Arun District Council
Arun Civic Centre
Maltravers Road
Littlehampton
West Sussex BN17 5LF
Planning & Building Control General Enquiries
Tel: (01903) 737756 Fax: (01903) 730442
Dx: 57406 Littlehampton
Minicom: 01903 732765
e-mail: planning@arun.gov.uk
website: www.arun.gov.uk/planning

Application No: EP/126/20/HH
Site Address: 56 Angmering Lane East Preston BN16 2TA
Description of works: Resubmission (EP/37/20/HH) of proposed extensive refurbishment of existing 2-storey dwelling to include, single storey side/rear extensions, 2-storey rear extension, roof extension and front double garage

Thank you for your internet representation made on 28th November 2020 which has been recorded as an objection with the comments as follows:

Job Number: Drawing Number: 05 Revision: A

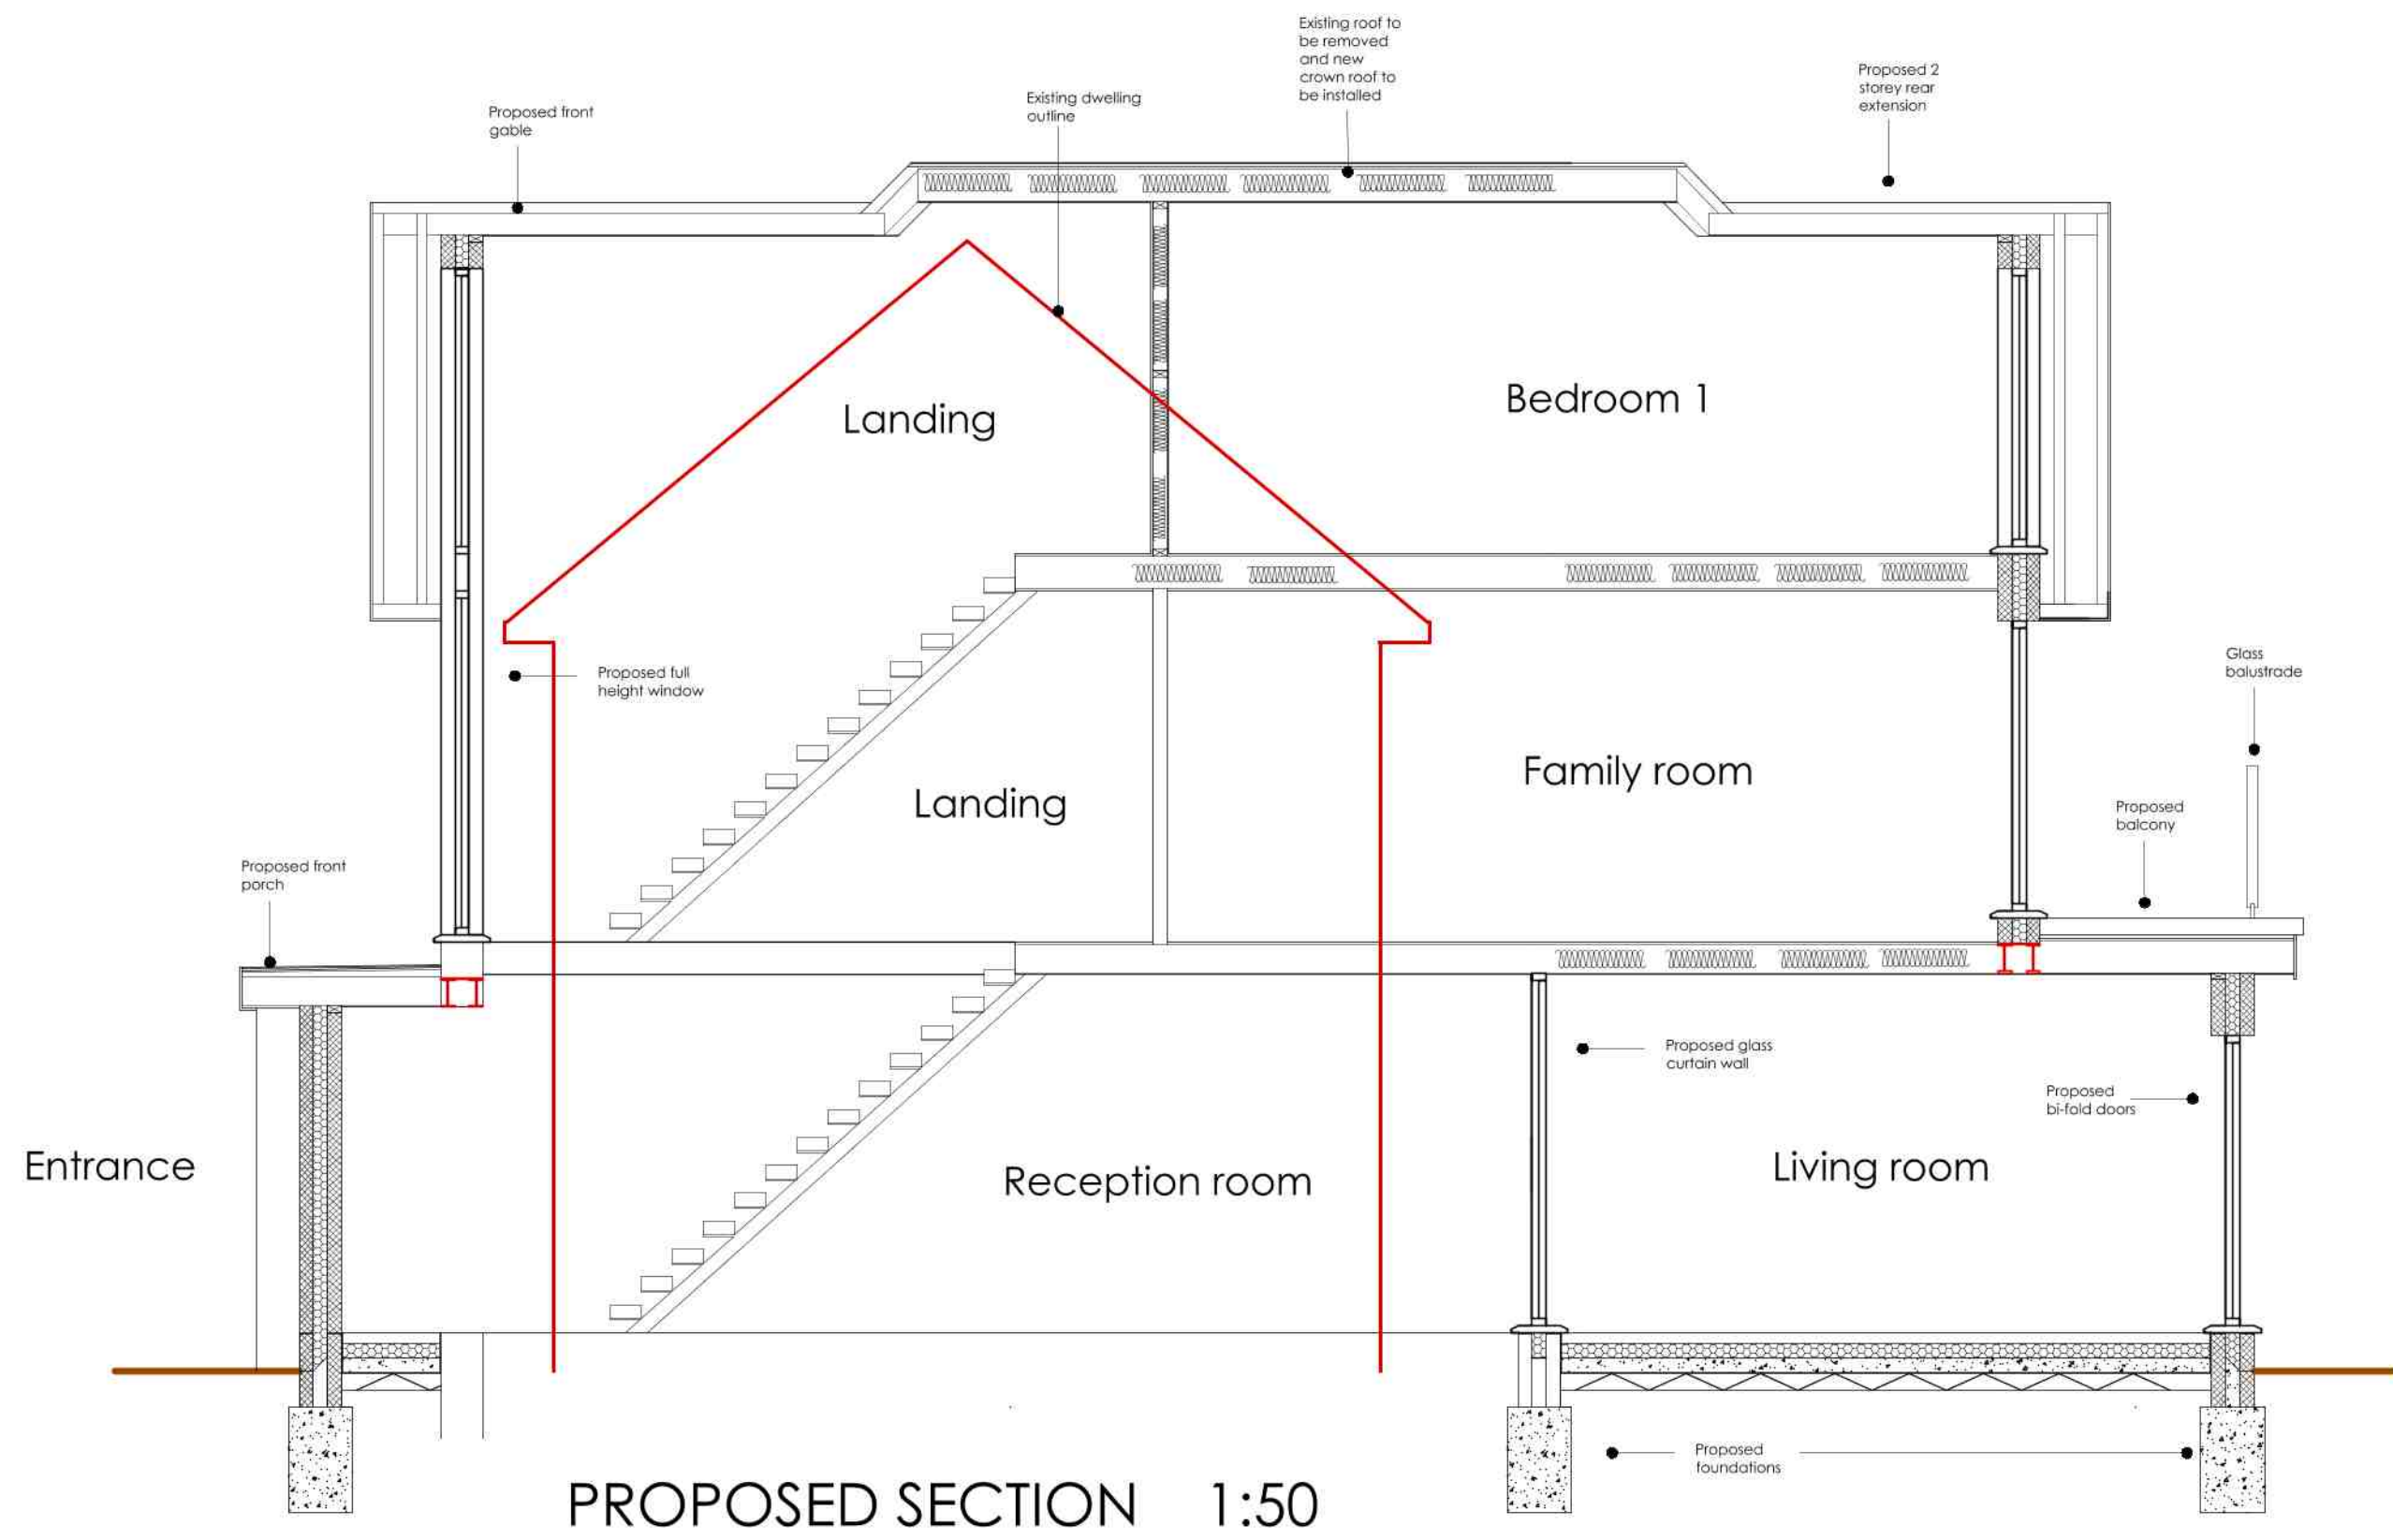
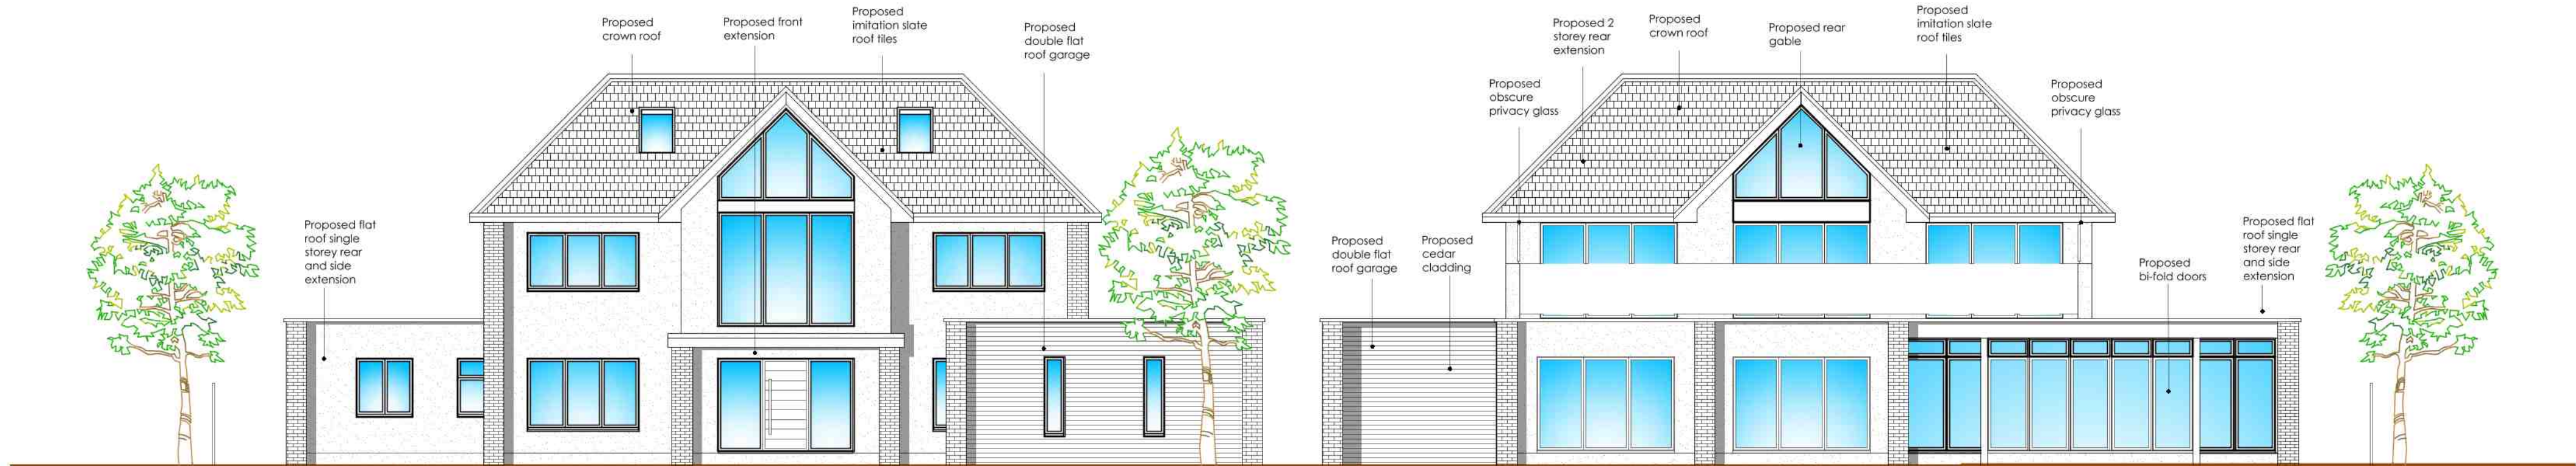
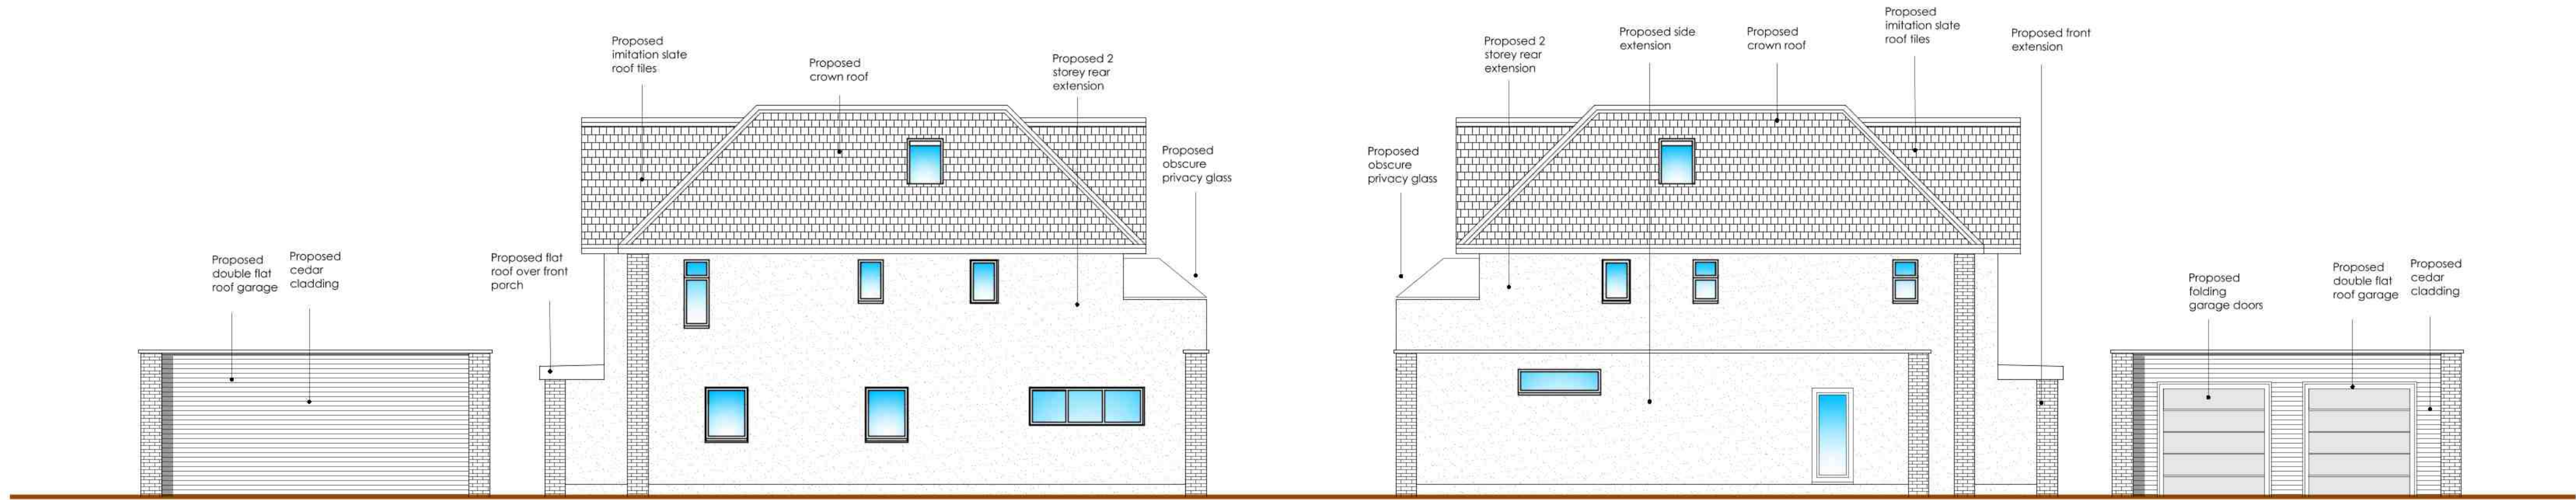
The inclusion of the Second Storey with its flat roof and large expanses of glass would create a serious overlooking of the rear gardens of adjacent properties. There are no other properties on the Willowhayne Estate with a second storey.
